**Consultation Response from KC,
Trees**

2025/93528 80, Marsh Lane, Shepley, Huddersfield, HD8 8AS

**Demolition of existing dwelling and annex and erection of 3 detached dwellings with
associated access and parking**

Date Responded: 27.01.2026

Appendix 1 - Arboricultural Impact Assessment Plan For
 80 Marsh Lane, Shepley, Huddersfield,
 HDB BAS
 TSC LTD 007 AIA
 Date: 20th December 2025
 Scale: 1:200 at A1 Page: 28 of 32
 By Flora Harding For Treescapes Consultancy Ltd

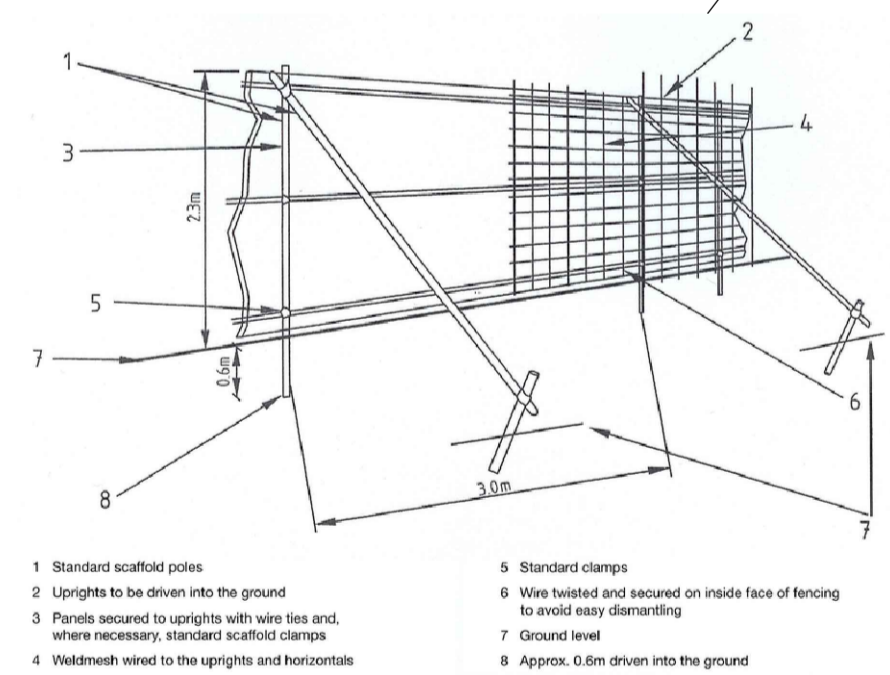
On a separate matter, it is noted that there is little space between the Plot 1 and T1 and T2. The Arboricultural Impact Assessment Plan dated 20/12/2025, shows no working space allowed between the Plot 1 and the tree protection fencing (TPF) surrounding T1 and T2. This is likely impracticable and could result in the TPF being removed during construction. This would create a foreseeable opportunity for accidental damage to occur to T1 and T2.

T1 and T2 are not at their mature size, and it is likely that the edge of the canopy of T2 would require remedial pruning away from the building on Plot 1 in the future. In line with BS5837: 2012, good design accounts for the projected final size of retained trees, not just their current form. Buildings should be adequately set back from retained trees to avoid foreseeable issues from developing in the future.
